Application No: R/61/21/CLP
Site Address: 33 Knightscroft Avenue Rustington BN16 2HW
Description of works: Lawful development certificate for a proposed outbuilding ancillary to main dwelling.

Thank you for your internet representation made on 27th April 2021 which has been recorded as an objection with the comments as follows:

OWPC35464

March 2021
Drawing no:JB 416/ certificate of lawfulness 03

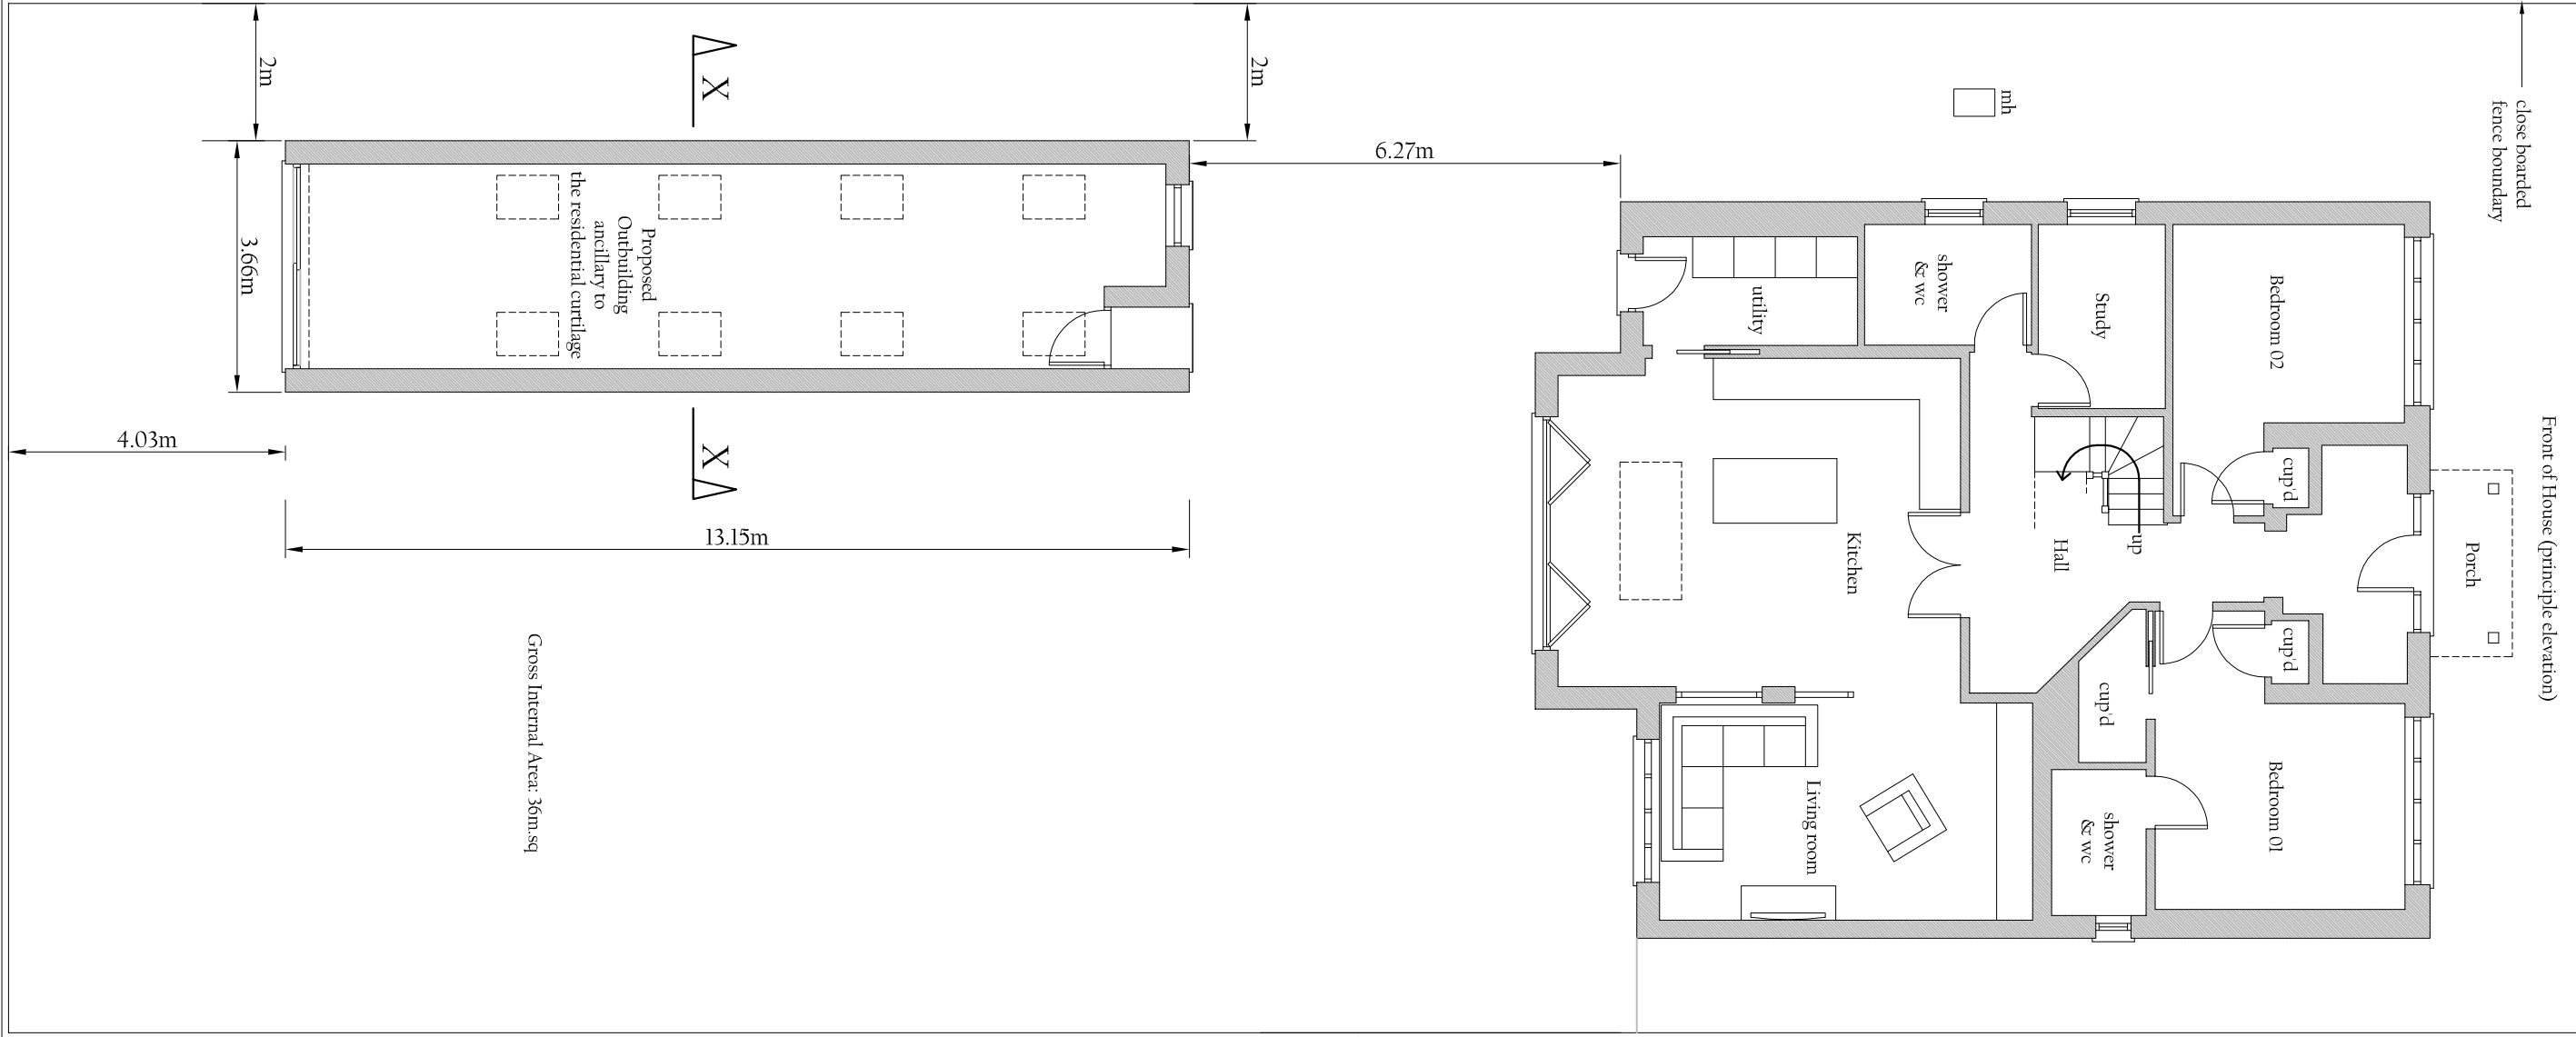
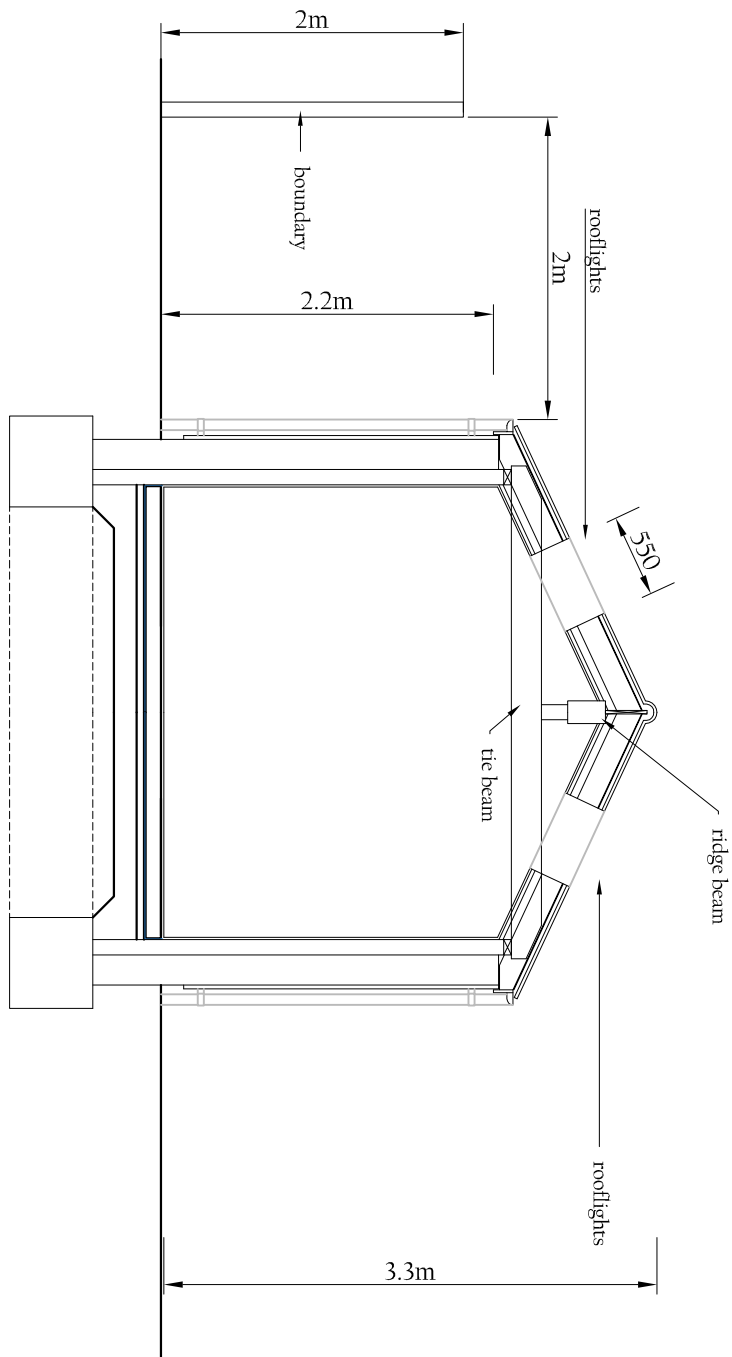
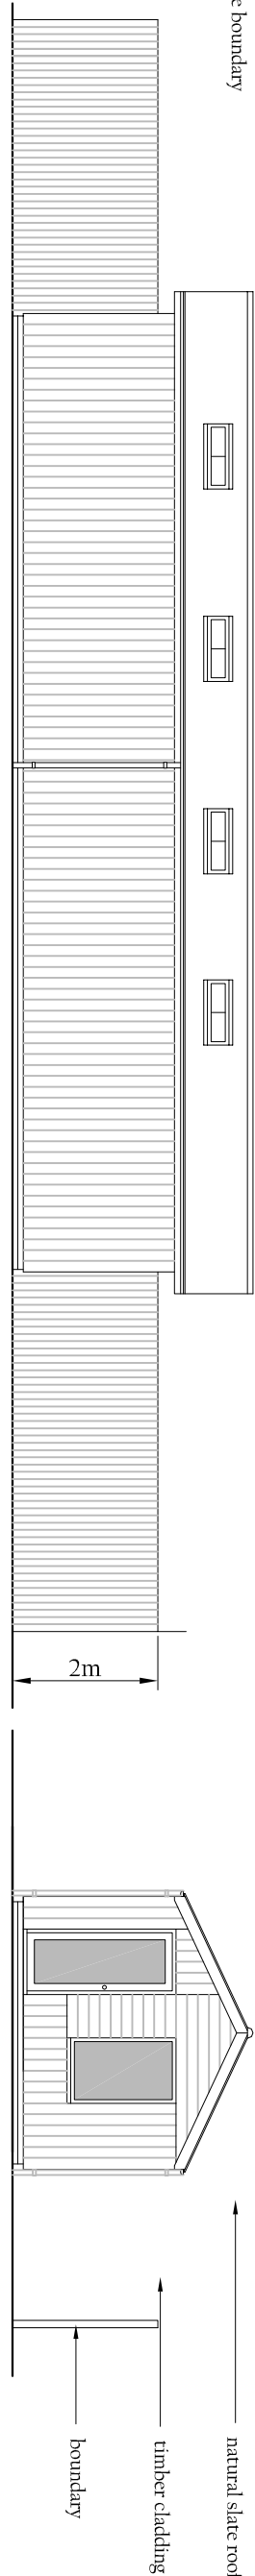
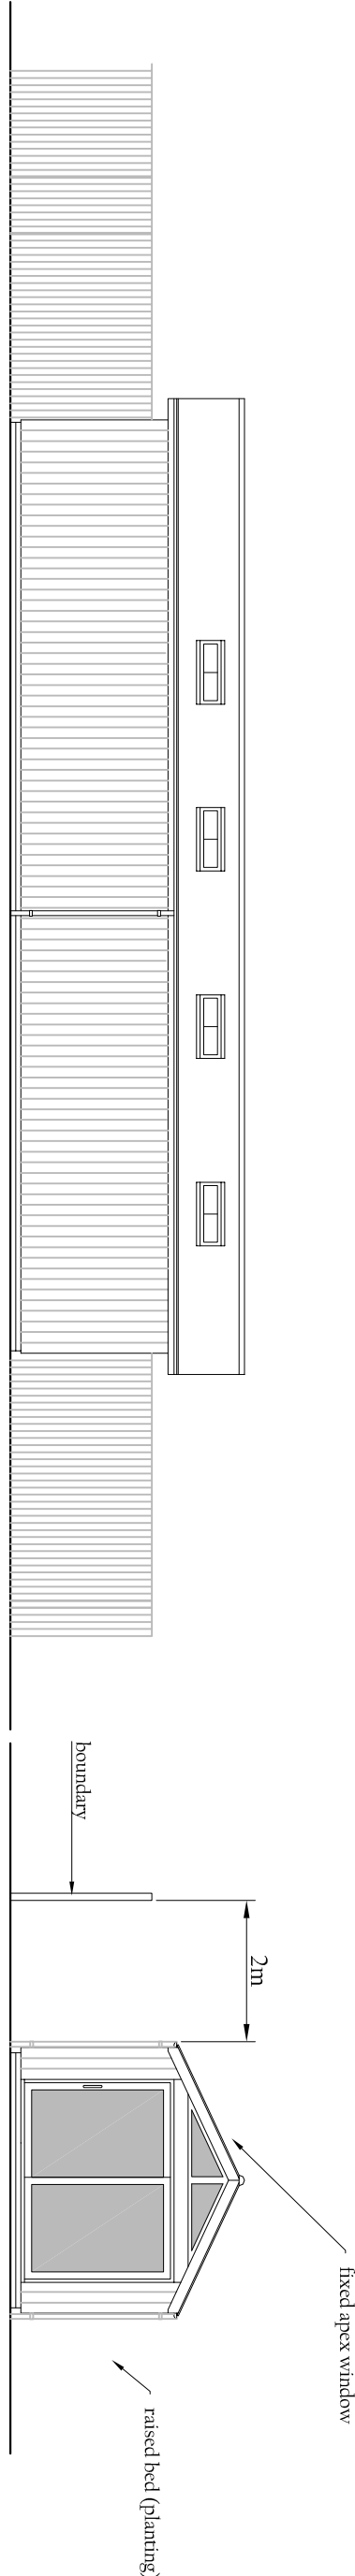
It was also considered grossly disproportionate, in several dimensions, which have hardly changed in this application

The newly submitted plans with just a one metre reduction in width, could still be used as living accommodation if fitted out accordingly, once the shell is complete. We note that the same architect has simply failed to provide any internal plans presumably hoping to push the application through, without further comment.
